Please ask for: Ms Iqraa Malik
Email: iqraa.malik@terraquest.co.uk
Telephone: 01212341390
Our Ref: R/25/21/HH
Your Ref:
Date: 12th February 2021

Application for Planning Permission for Works or Extension to a Dwelling

Development: Glazed Gable Extension and the addition of a porch.
Location: 34 The Crescent Rustington BN16 2PF

A :: Block Plan
03 scale: 1:200

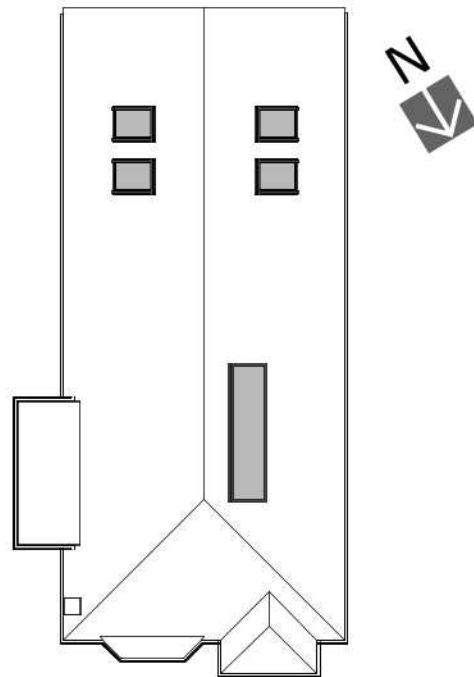
Dimensions: You are required to include dimensions from the proposed extension to all site boundaries.
